Transport
for NSW

**Blacktown Hospital Stage 2 Concept Proposal and Enabling Works (SSD 7058)
Notice of Exhibition**

TAB A – Request for Further Information/Clarification

Figure 20 New Hospital Access to Blacktown Road opposite Baronta Street

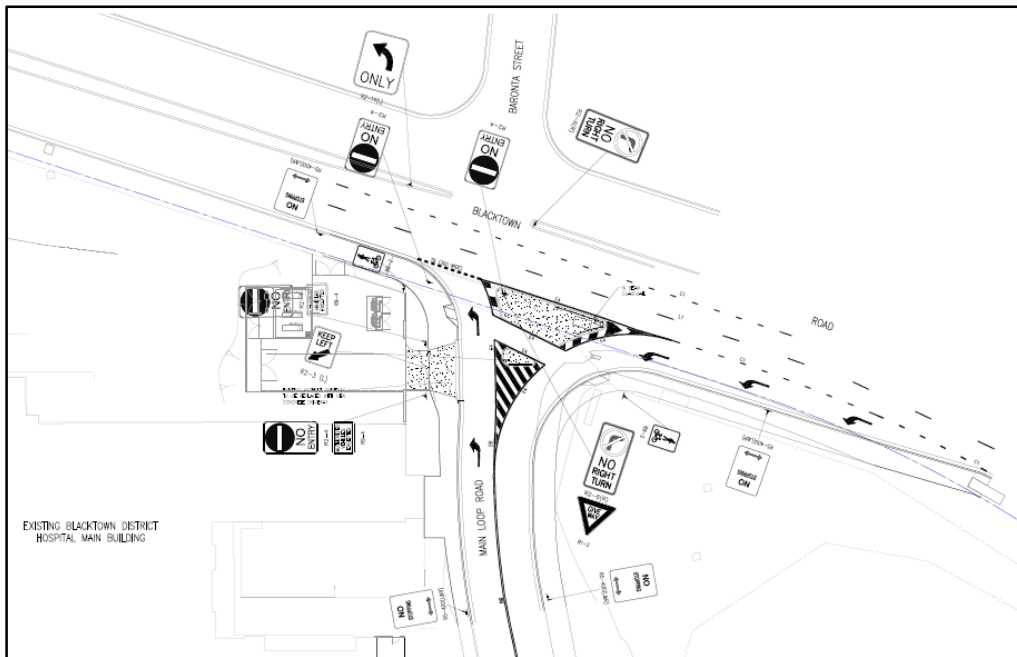
The proposed development will increase traffic movements at the Wall Park Avenue/Blacktown Road/Baronta Street intersection. Increase in traffic movements at this uncontrolled intersection would have the potential to create vehicle and pedestrian safety issues. There is a potential conflict between vehicles turning at this intersection and potential safety issues for the pedestrians crossing the slip lane.

TfNSW requests that a road safety audit be undertaken for the Wall Park Avenue/Blacktown Road/Baronta Street Intersection in accordance with *Austroads Guide to Road Safety Audit Part 6: Road Safety Audit* by an independent TfNSW accredited road safety auditor. Based on the results of the Road Safety Audit, the applicant may need to implement safety measures for this intersection with consultation with Roads and Maritime Services.
